Appeal Decision

Appeal Ref: APP/R5510/D/24/3342850

18 The Uplands, Ruislip, Hillingdon, HA4 8QN

- The appeal is made under section 78 of the Town and Country Planning Act 1990 (as amended) against a refusal to grant planning permission.
- The appeal is made by Mr N Solanki against the decision of the Council of the London Borough of Hillingdon.
- The application Ref is 65398/APP/2023/3462.
- The development proposed is a single storey rear infill, first floor side/rear extension, conversion of garage into habitable space and internal alterations.

PROPOSED GROUND FLOOR PLAN
SCALE 1:100@A1

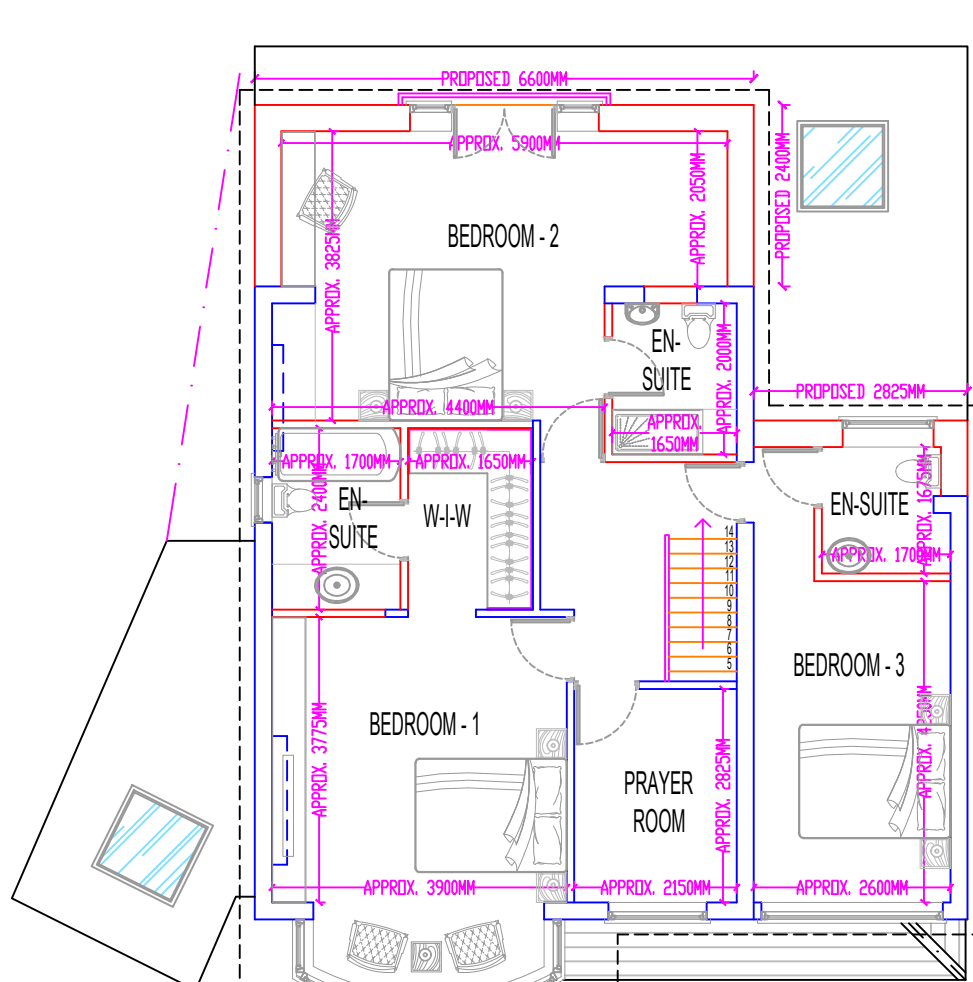
5. The Council raises no objection to the first floor side/rear extension nor to the conversion of the garage to habitable accommodation and other internal alterations. I agree these are acceptable. I shall therefore restrict my further consideration to the single storey rear infill extension. This would square off the corner of the existing single storey extension. It would involve an infill with a depth of some 1.8m and a width of about 2.8m. The roof would be some 3m high to match the roof of the existing extensions. A gap of some 1.65m at the far corner would remain between the extension and the boundary with No 16.

6. Policy DMHD 1 of the Council's Local Plan: Part 2 - Development Management Policies (DMP), 2020, states that single storey rear extensions to detached dwellings should not exceed 4m in depth. The existing extension closest to the boundary with No 16 appears to have been built with a depth of about 3.7m. An additional 1.8m is now proposed, clearly exceeding the 4m limit. The evidence shows that this would result in the extension impinging on a line drawn at 45 degrees from the centre of the closest window in No 16. This would limit the existing outlook from the window to the rear of No 18.

7. The appellant suggests that the loss of outlook would be minimal and notes that it is intended to increase the height of the boundary fence to 2m. However, owing to the rear of No 16 being angled towards the boundary of No 18, the loss of outlook within the main field of vision would be more pronounced than for a conventional layout. Notwithstanding the increase in fence height and the gap between the proposed extension and the boundary, a noticeable degree of visual intrusion would therefore result.

9. Turning to light, the position of No 16 to the south west of the appeal dwelling means that no material loss of sunlight or overshadowing would occur as a result of the proposed infill extension. Nevertheless, I find that the loss of outlook would, owing to the angled relationship between the two dwellings, be significant and that this would materially harm the living conditions of occupiers.

THE UPLANDS
PROPOSED SITE PLAN
SCALE 1:200 @A1

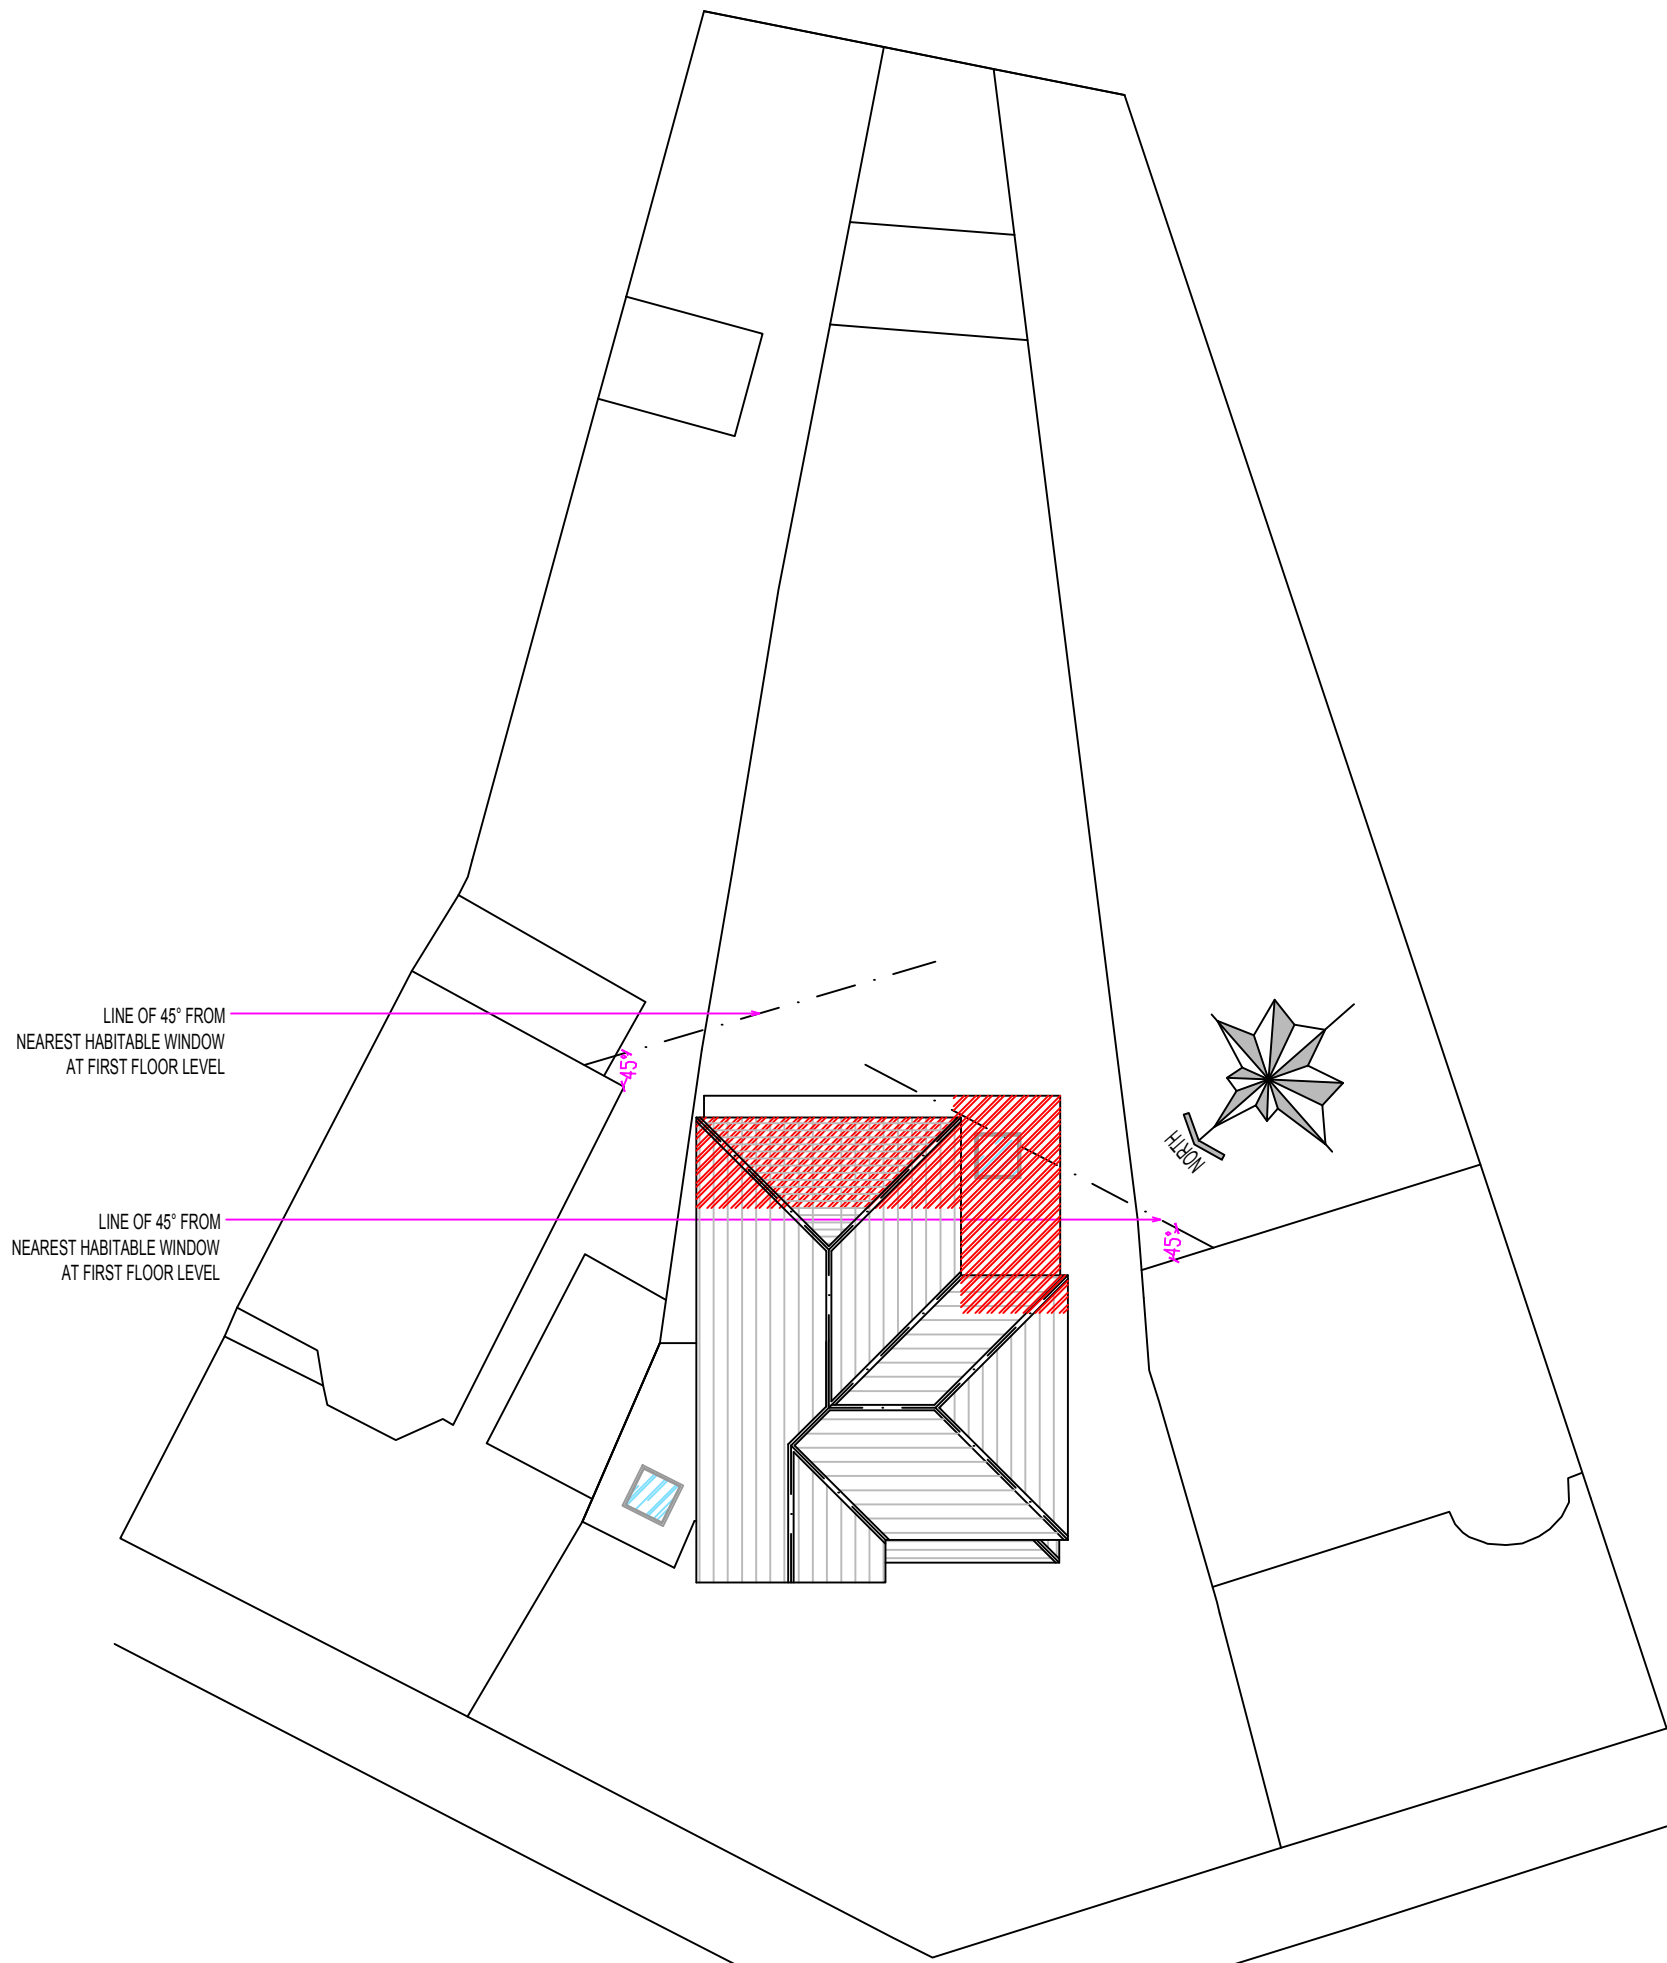
4. No 16 lies to the south west of the appeal site and the other neighbour, No 20 to the north east. Owing to the location of the three dwellings in a corner location, the rear elevations of Nos 16 and 20 are angled towards the appeal dwelling. The rear elevation of No 16, which has not been extended is also set back from that at No 18.
